Your ref: SSD10154

Subject: Notice of Exhibition – Qantas Flight Training Centre – SSD 10154

EES comments on Notice of Exhibition – Qantas Flight Training Centre – SSD 10154

1 SITE - DEMOLITION
1:500

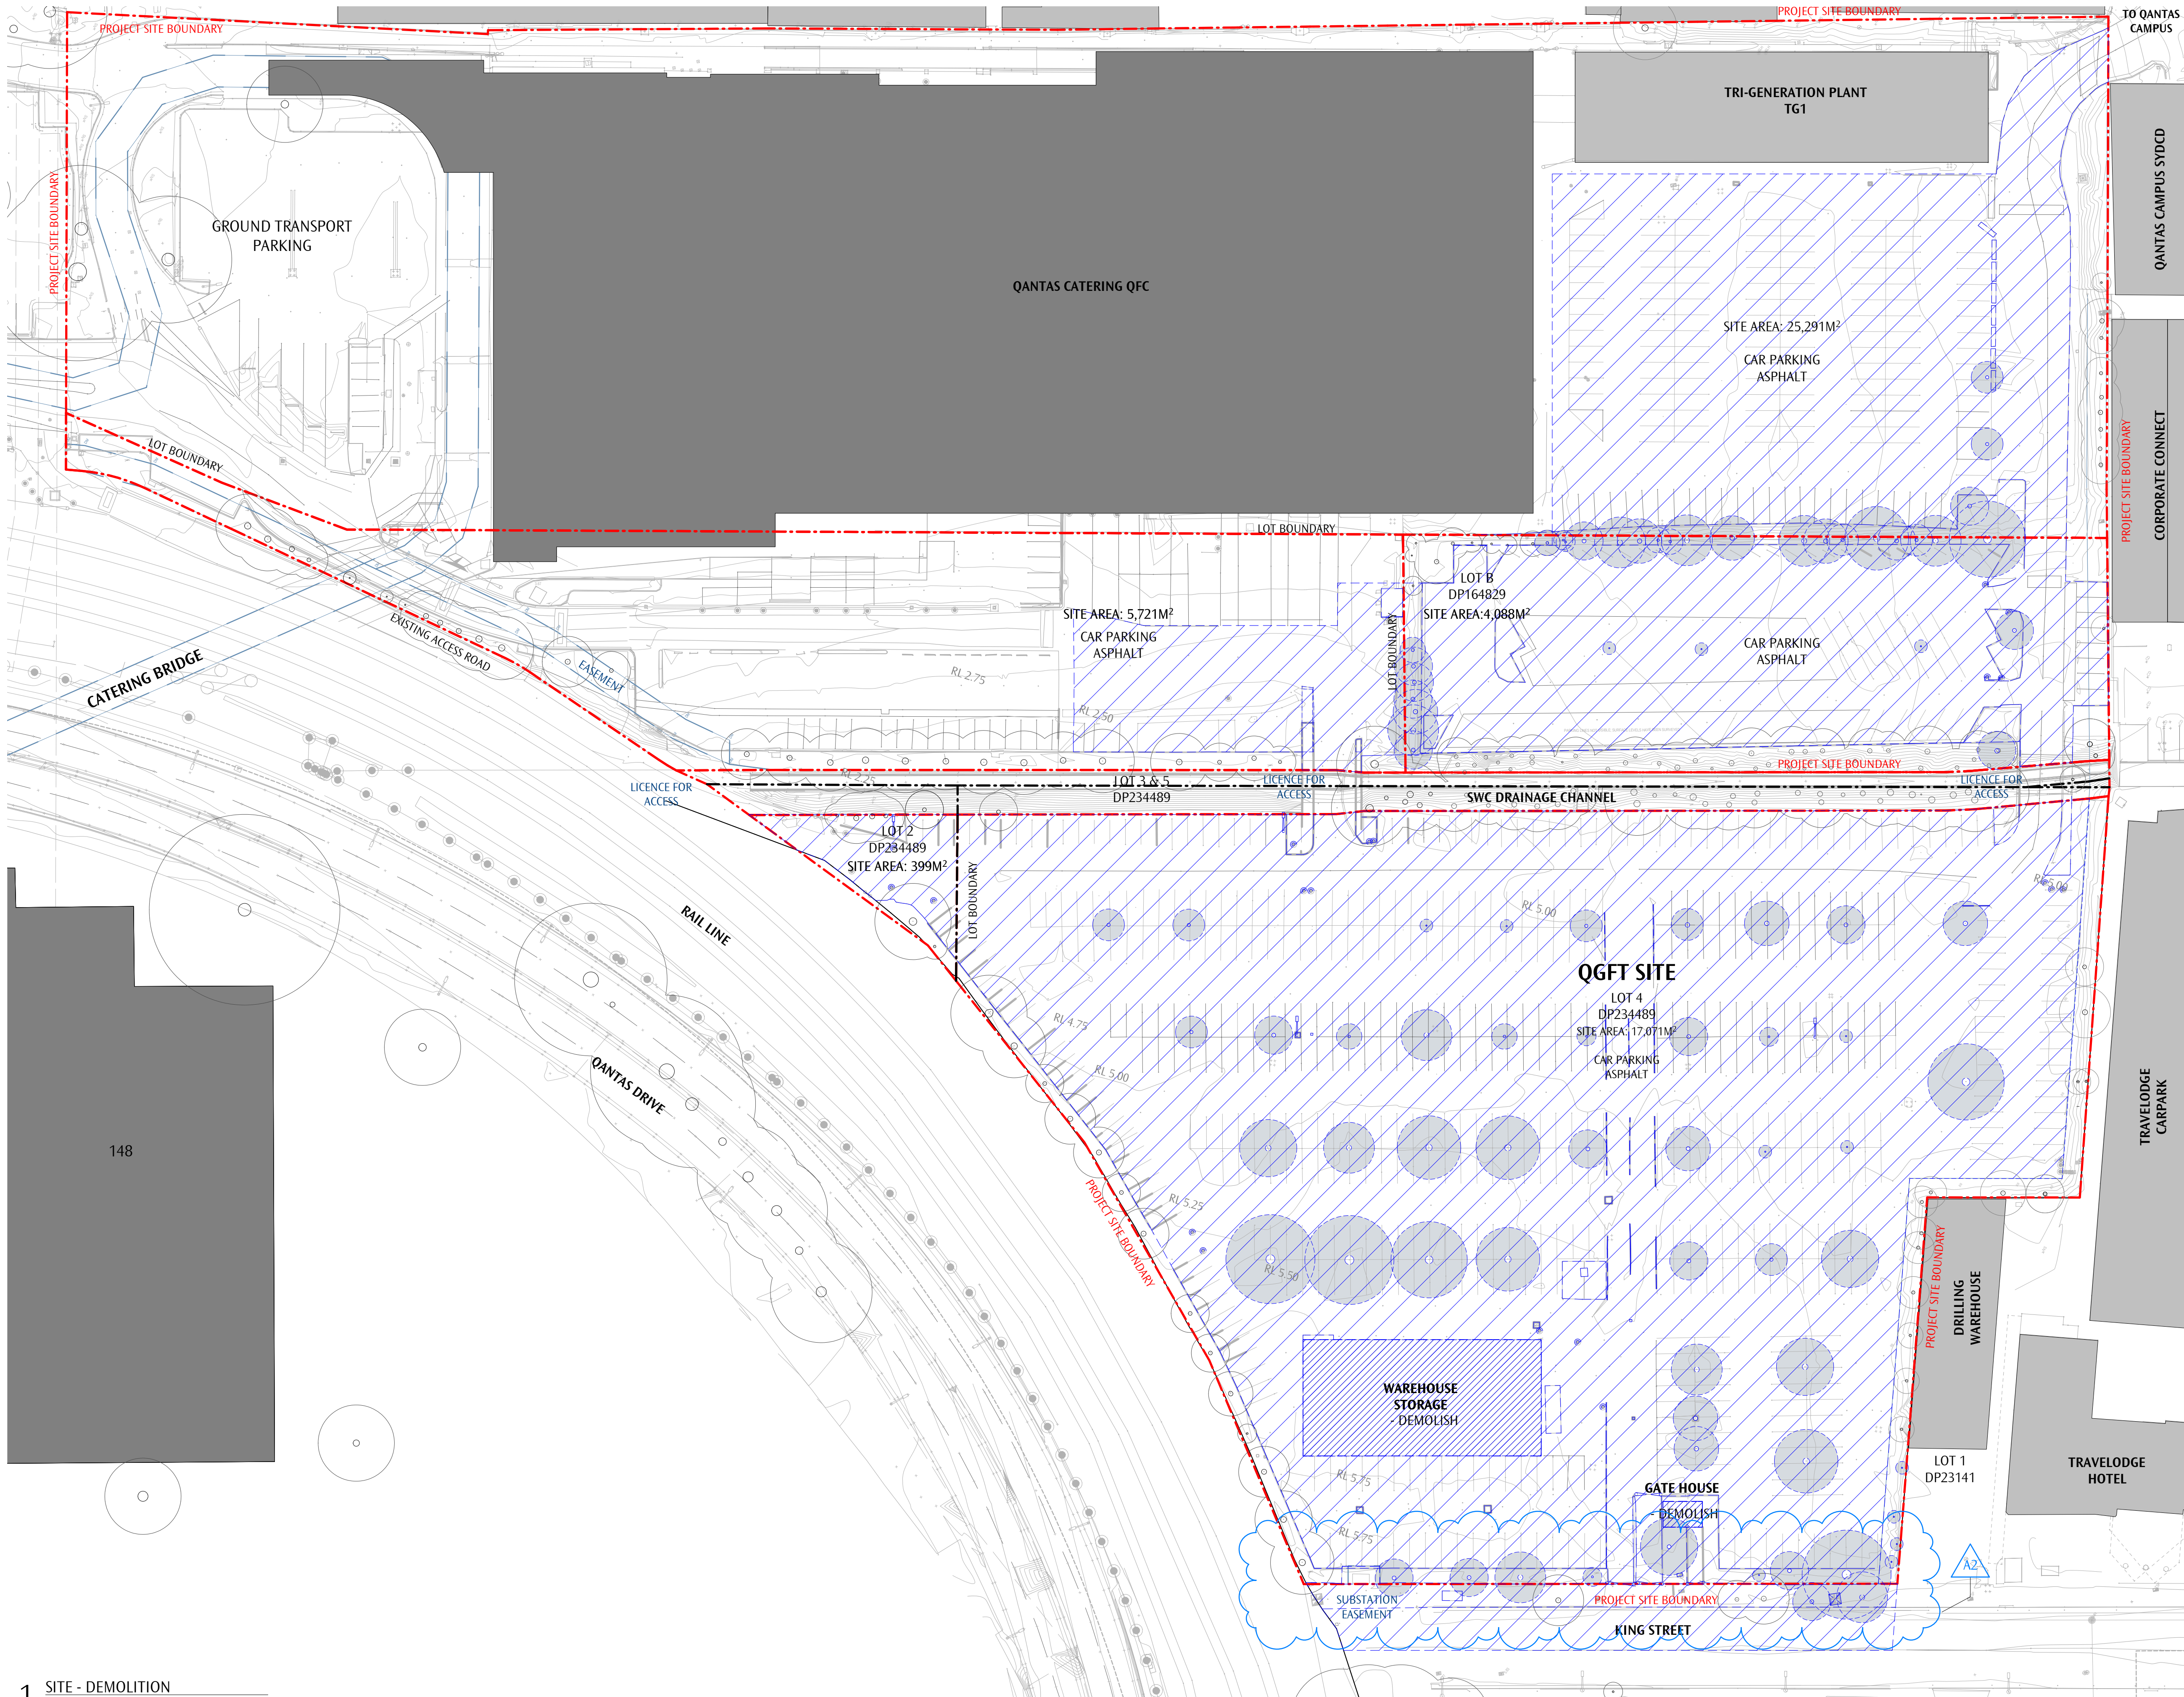
EES notes the proposal includes the demolition of the existing warehouse storage building and disused gatehouse. The EIS (section 7.4, page 97) and BDAR (section 9.3.2, page 38) note that no human made structures have been identified within the site that would provide a suitable habitat for any threatened species, but no further details are provided to support this. The BDAR has not considered the presence and possible value of habitats afforded by the existing artificial/built structures, for example the existing warehouse storage building and disused gatehouse. Several microchiropteran bat species, some threatened, are capable of roosting in a variety of natural and constructed sites, so it is possible that they might utilise the built features on this site.

More information is required to confirm the absence of roosting habitat for threatened microbats within the existing buildings. A search for evidence of microbat roosts should be undertaken using appropriate methods, such as those described on page 9 of the "Species credit' threatened bats and their habitats NSW survey guide for the Biodiversity Assessment Method (OEH 2018)". Attention should be given to inspecting cracks or seams in the roofs and a handheld bat detector of ultrasonic calls can assist in alerting the searcher to the presence of bats. Searches must be undertaken by someone with appropriate experience, as described on page 5 of that guide. If bats or signs of bats are observed, the bats may need to be captured to identify species and breeding status using traps, nets or other methods. The information provided should include photographs of any holes, cracks or crevices that were searched; any associated observations about bats and/or signs of bats; and any results from a bat call detector.

- A2
- KING ST. TREES AMENDED
 - LANDSCAPE AREAS/TREES ADDED
 - CAR SPACE DELETED
 - RAINWATER TANK ADDED

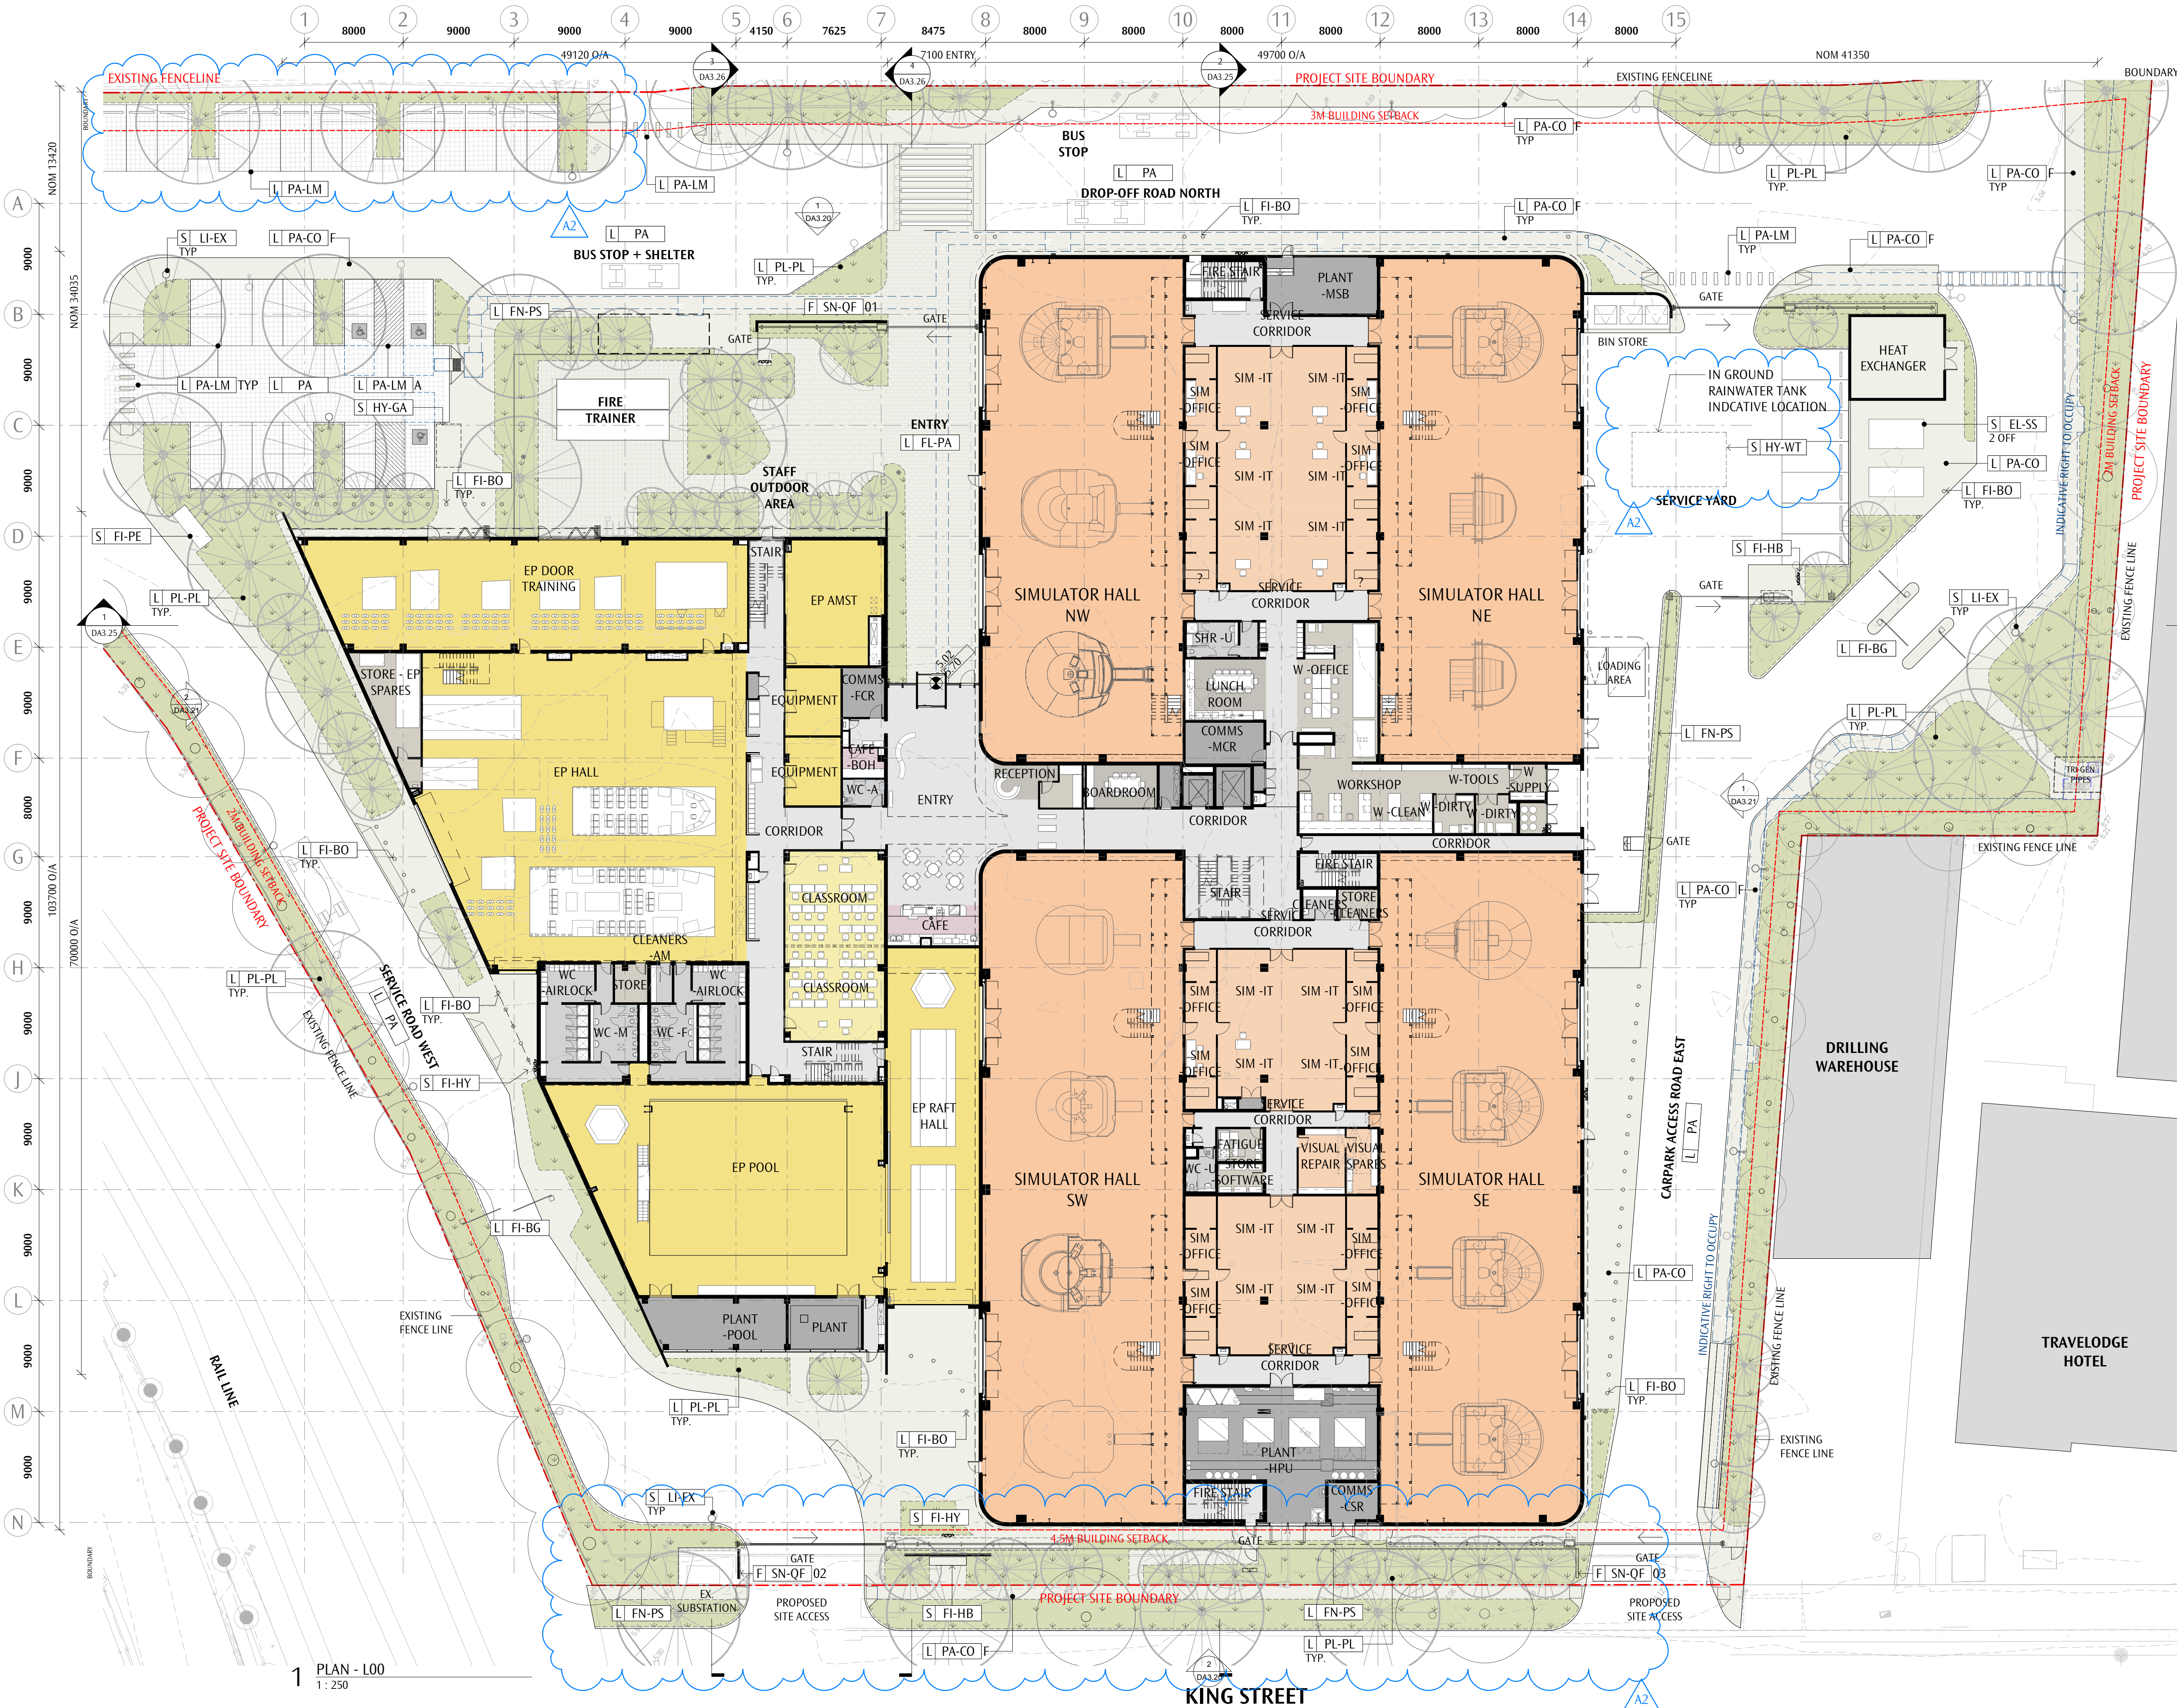
The EIS includes a mitigation measure for the replanting of landscape areas to incorporate native species as per the Landscape Plan and for replacement landscaping to keep in context with the existing character of the property. The former OEH in its SEARs submission recommended the site landscaping use a diversity of local provenance species (trees, shrubs and groundcovers) from the native vegetation community (or communities) that once occurred on the site rather than using exotic plant species or non-endemic native species. EES repeats this recommendation as the use of local genetic plant material has numerous environmental benefits. As the BDAR notes that multiple mature Plane Trees are scattered throughout the site (section 1.2) and that most of the vegetation to be removed for the project is not native vegetation and comprises exotic plants or planted often non-indigenous native species (section 9.1.1), it is recommended the requirement for replacement landscaping to keep in context with the existing character of the property is deleted and the mitigation measure is amended as follows:

- replanting of landscape areas to incorporate **a diversity of local provenance native species from the native vegetation community (or communities) that once occurred in the local area** as per Landscape Plan. Replacement landscaping should keep in context with the existing character of the property.

EES recommends the following additional mitigation measures are also included to assist mitigate the loss of existing urban tree canopy from the site, reduce the urban heat island effect, enhance local habitat etc:

- any trees that are to be planted at the site or in the street shall use advanced and established local native species from the relevant vegetation communities which once occurred in the locality, preferably with a minimum tree height of 2-2.5 metres and /or plant container pot size of 50-75 litres to assist mitigation of the removal of trees, as the loss of existing trees from the site and the benefits that they provide takes years for a juvenile tree to grow and replace
- enough area/space is provided to allow the trees to grow to maturity.
